From: Paton, Julie <Julie.Paton@lancashire.gov.uk>
Sent: 23 October 2023 17:32
To: Planning
Subject: 3/2023/0654 The Old Coach House Saccary Lane Mellor BB1 9DL
Attachments: 3 2023 0654 Overlay.pdf

Reference 3/2023/0654
Location The Old Coach House Saccary Lane Mellor BB1 9DL
Proposal Proposed home office/gym/ family accommodation on land to the rear.

Floor Plan - (Scale - 1:50)

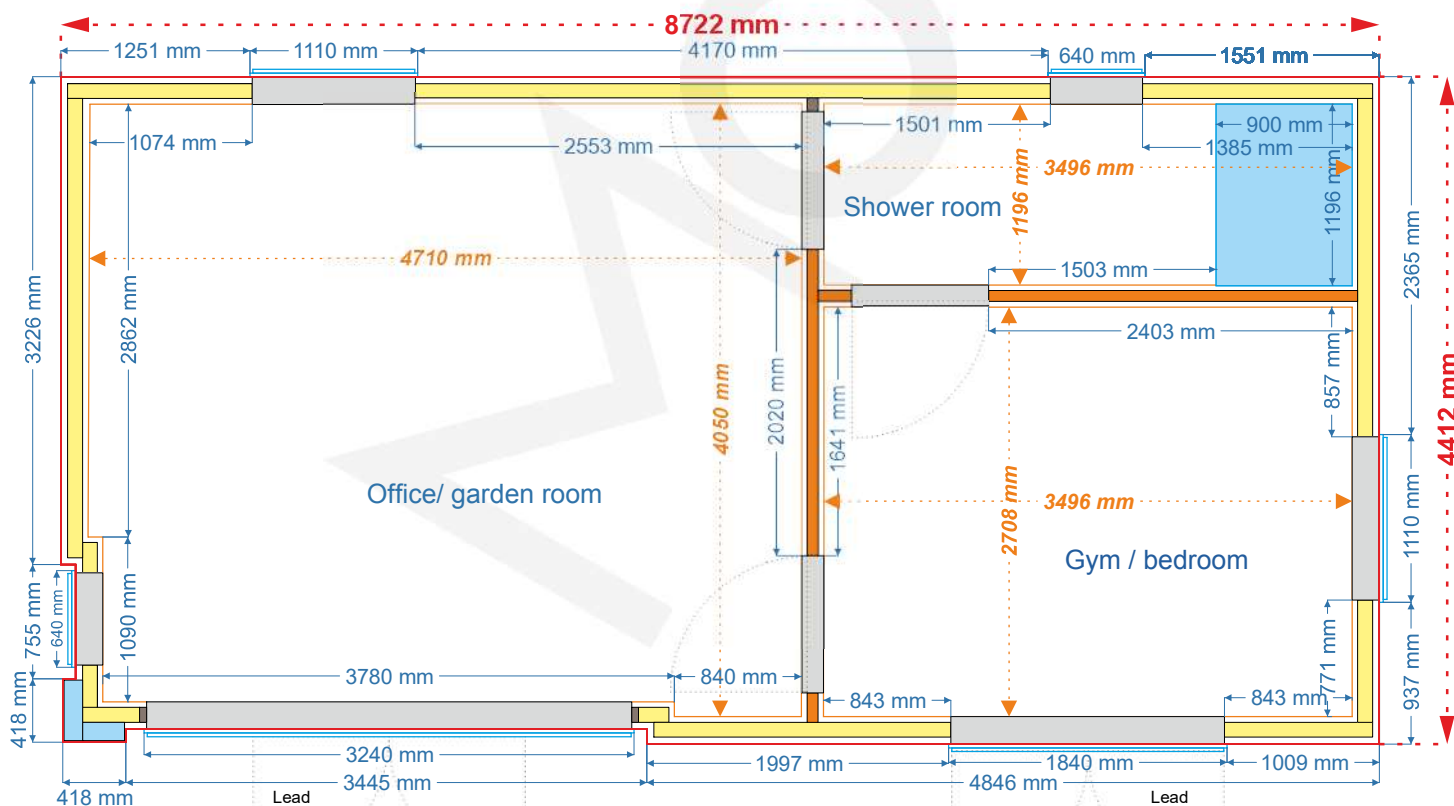
The proposed building will obstruct footpath FP0325018, as shown on the attached overlay, triggering a Diversion Order under the provisions of the Town and Country Planning Act 1990 Section 257 (TCPA90 S257). TCPA90 S257 orders are administered by the authority that is considering, or has granted the planning permission, in this instance Ribble Valley Borough Council.

The detail of the exact alignment of the new route, the construction specification and any association works would need to be agreed with public rights of way before the necessary TCPA90 S257 Order is made. I can advise that the new route must have a minimum width of 2 metres, have a firm properly constructed surface with no gates or stiles crossing the new route.
